# Rezoning Transportation Analysis

Petition Number: 2024-008

General Location Identifier: 17316317

Date	Description
2-21-24	First Review (NK)
3-20-24	Second Review (NK)
4-24-24	Third Review (NK)
7-2-24	Fourth Review (NK)

RZ01 - REZONING PLAN

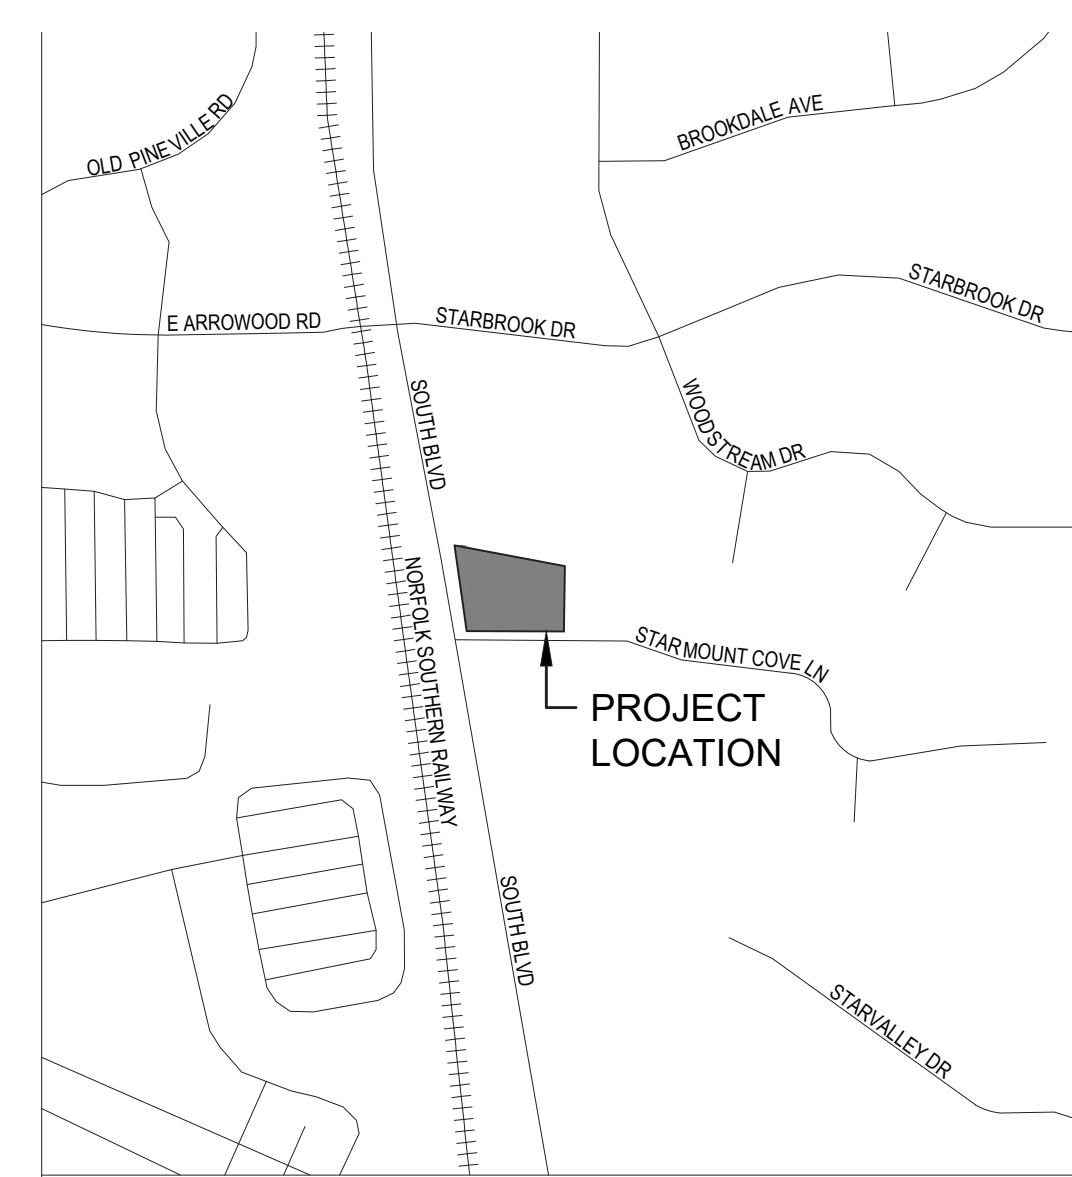
a. ~~Road Name South Boulevard:~~ The future location of the back of curb and gutter is 38' from the road centerline.

~~Label and dimension the curb and gutter from the centerline for each road on the site plan.~~

b. ~~Road Name Starmount Cove Lane:~~ The future location of the back of curb and gutter is 20.5' from the road centerline.

~~Label and dimension the curb and gutter from the centerline for each road on the site plan.~~

- ~~3. Revise site plan and conditional note(s) to commit to dedicate 56' right-of-way from the South Boulevard road centerline. The site plan shall label and dimension the right-of-way from the road centerline.~~

- ~~4. Revise site plan and conditional note(s) to commit to dedicate 38.5' right-of-way from the Starmount Cove Lane road centerline. The site plan shall label and dimension the right-of-way from the road centerline.~~

- ~~6. Revise site plan and conditional note(s) to commit to installing 8' planting strip and 8' sidewalk along South Blvd and Starmount Cove Lane per UDO article 32.7. Streetscape should be located at the future back of curb location.~~

- ~~7. Revise site plan and conditional note(s) to commit to removing driveway located on South Boulevard. Per Charlotte Streets Manual table 2.1, access priorities would be as follows before individual driveway:

~~— **Clarifying Comment 3-20-24:** NCDOT / CDOT will agree to allow a 65 degree skewed right out driveway off of South Blvd, and the median will need to be extended past the driveway entrance.~~

- ~~11. **New Comment 4.24.24:** Add a conditional note to commit to installing 8' sidewalk and an 8' planting strip along South Blvd and Starmount Cove Lane as shown on plans.~~

- ~~12. **New Comment 4.24.24:** Please clarify on plans if the existing curb is remaining or if it is being relocated to future back of curb. Curb relocation is not required, but the sidewalk and planting strip should continue to be shown based on future curb location.~~
